Re: Capital II Wind Farm (MP 10_0135) Exhibition of Environmental Assessment

I&I NSW has reviewed the Environmental Assessment (EA) for the Capital II Wind Farm by Monteath & Powys Pty Ltd (dated December 2010) and Appendices and makes the following comments. This is a coordinated response from I&I NSW.

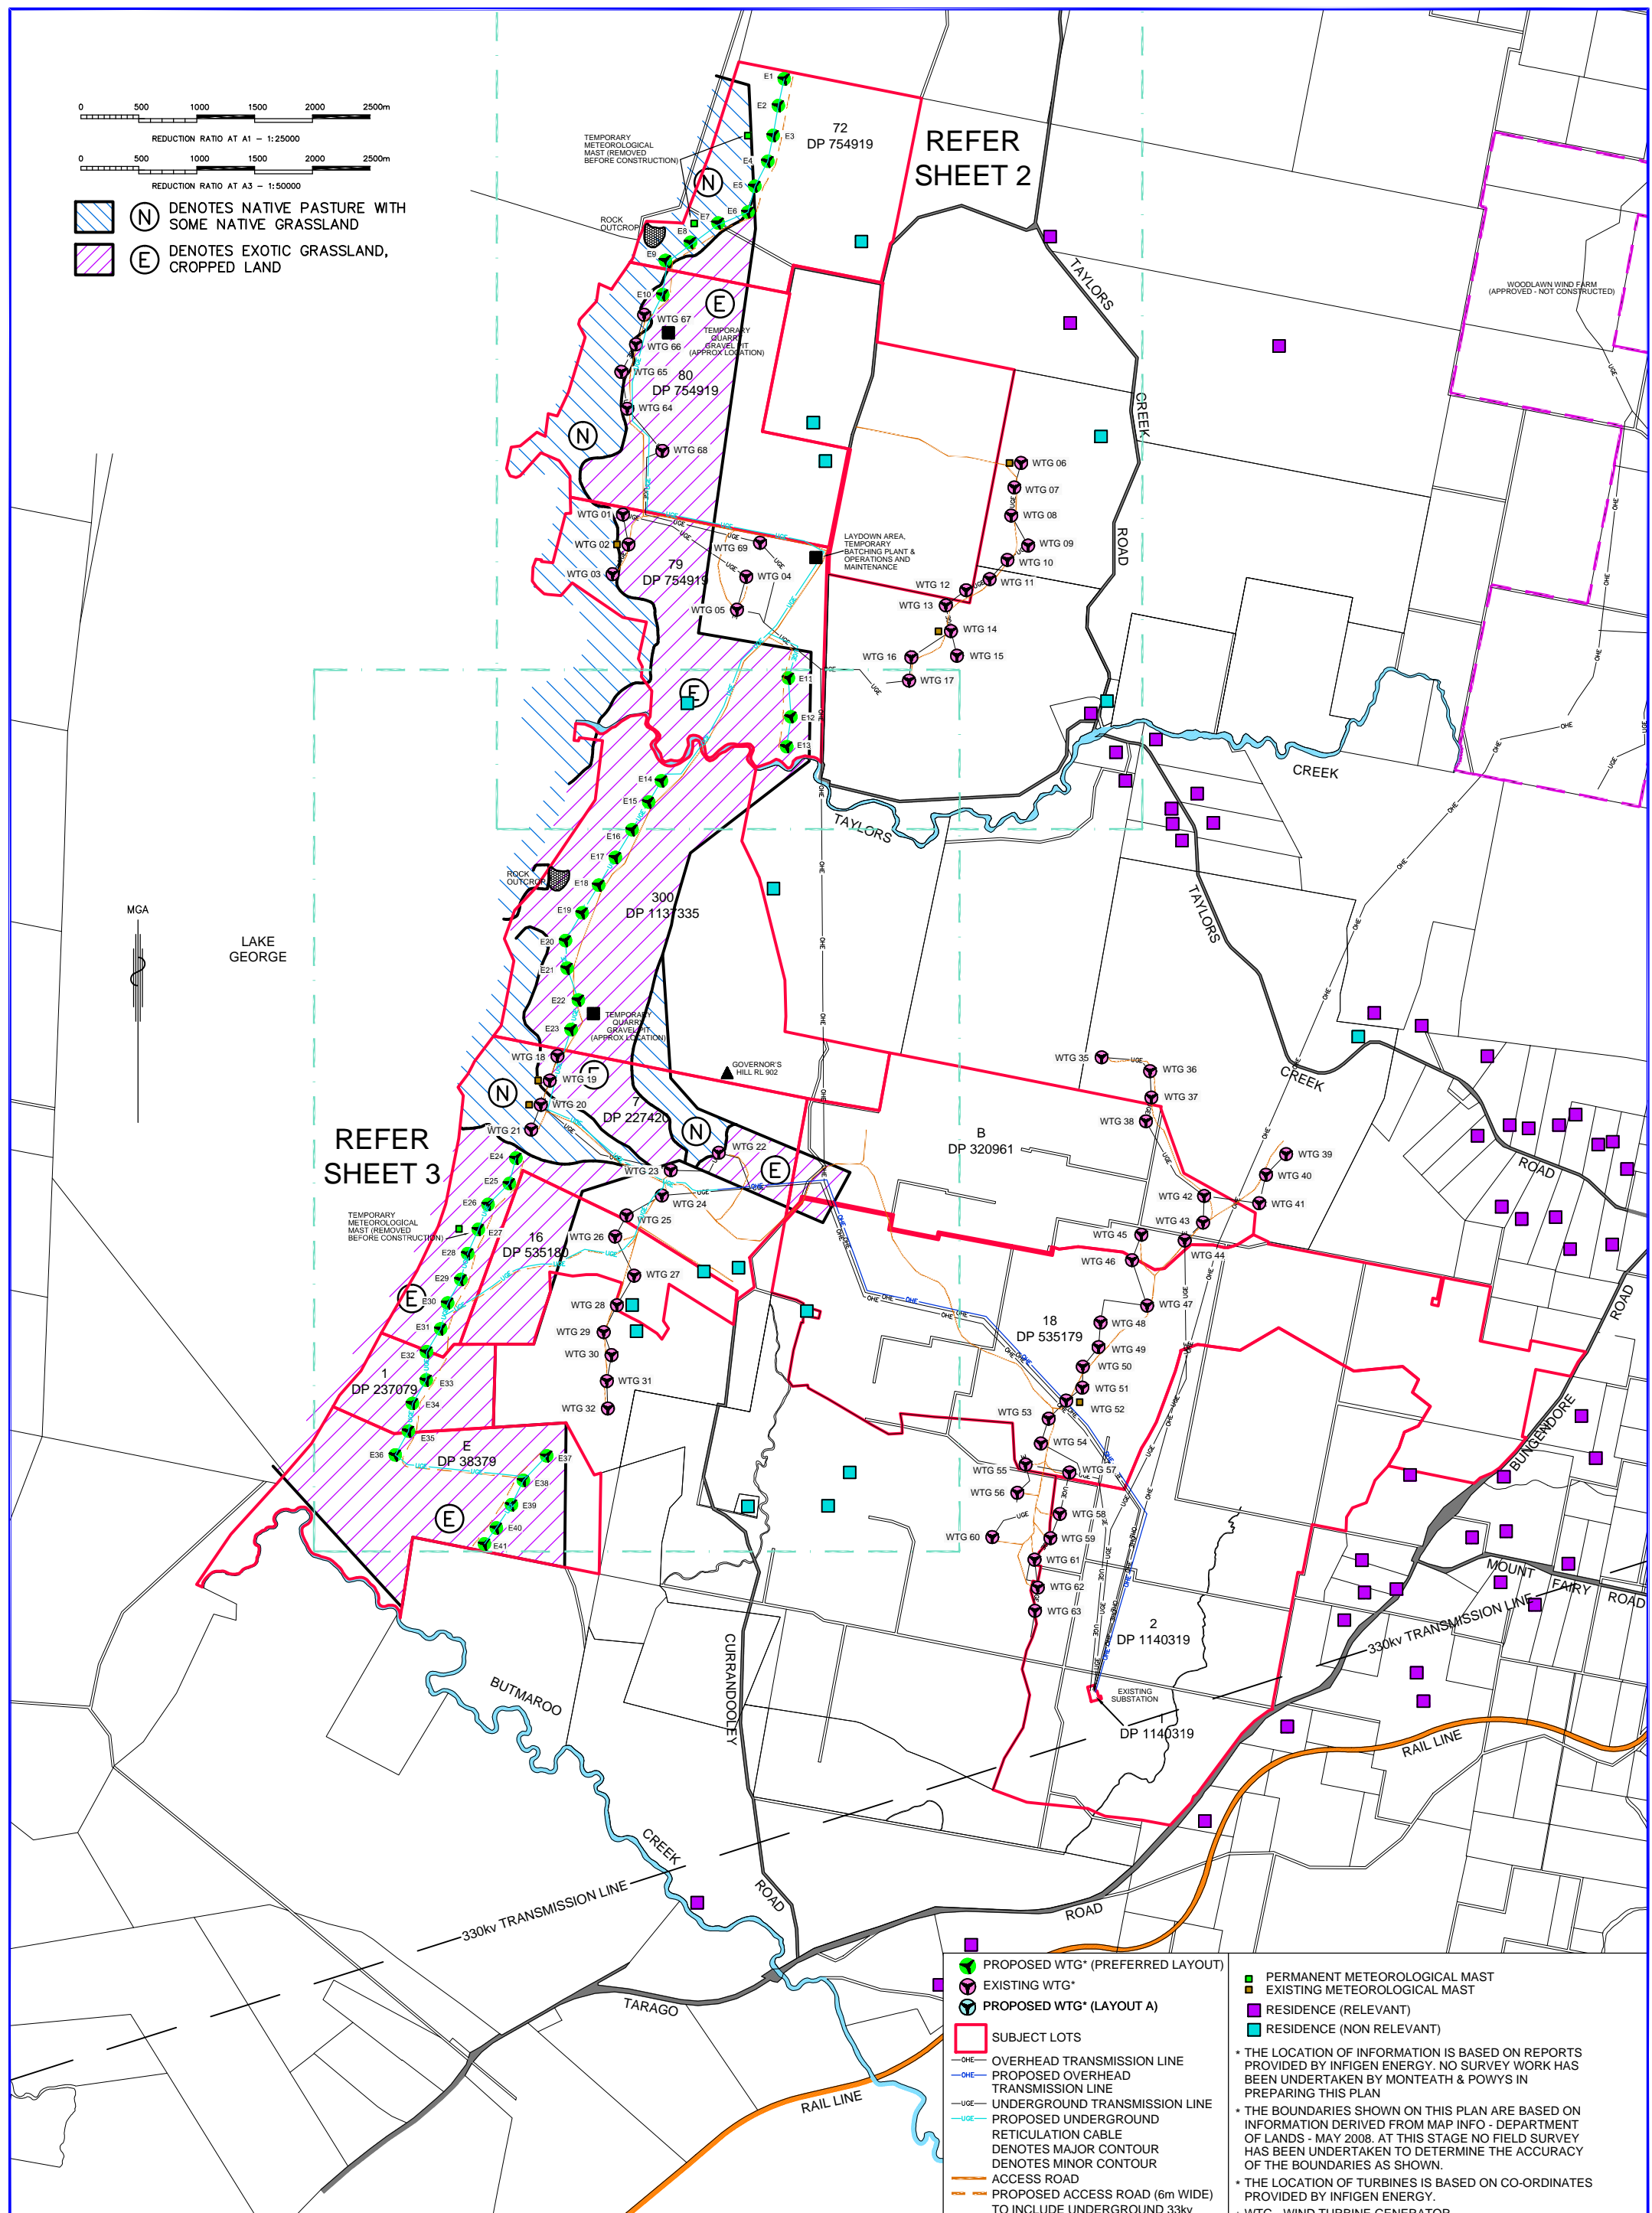
In assessing the proposed turbine layouts A and B (Volume 1 - Figures 26, 27, 30 & 31) it is apparent that the majority of sites are located within areas considered to have high potential for significant sand and gravel resources. The closely spaced nature of the turbines, particularly in layout A would seriously constrain or preclude future extraction of these resources. Layouts A and B are included at **Tab A**.

Given that the EA has not adequately assessed the impact of the project on potential sand and gravel resources in the project area, I&I NSW does not support the proposed wind farm in its current form. The Department requests that the proposed turbine locations be reviewed and, where possible, relocated in order to minimise potential resource sterilisation.
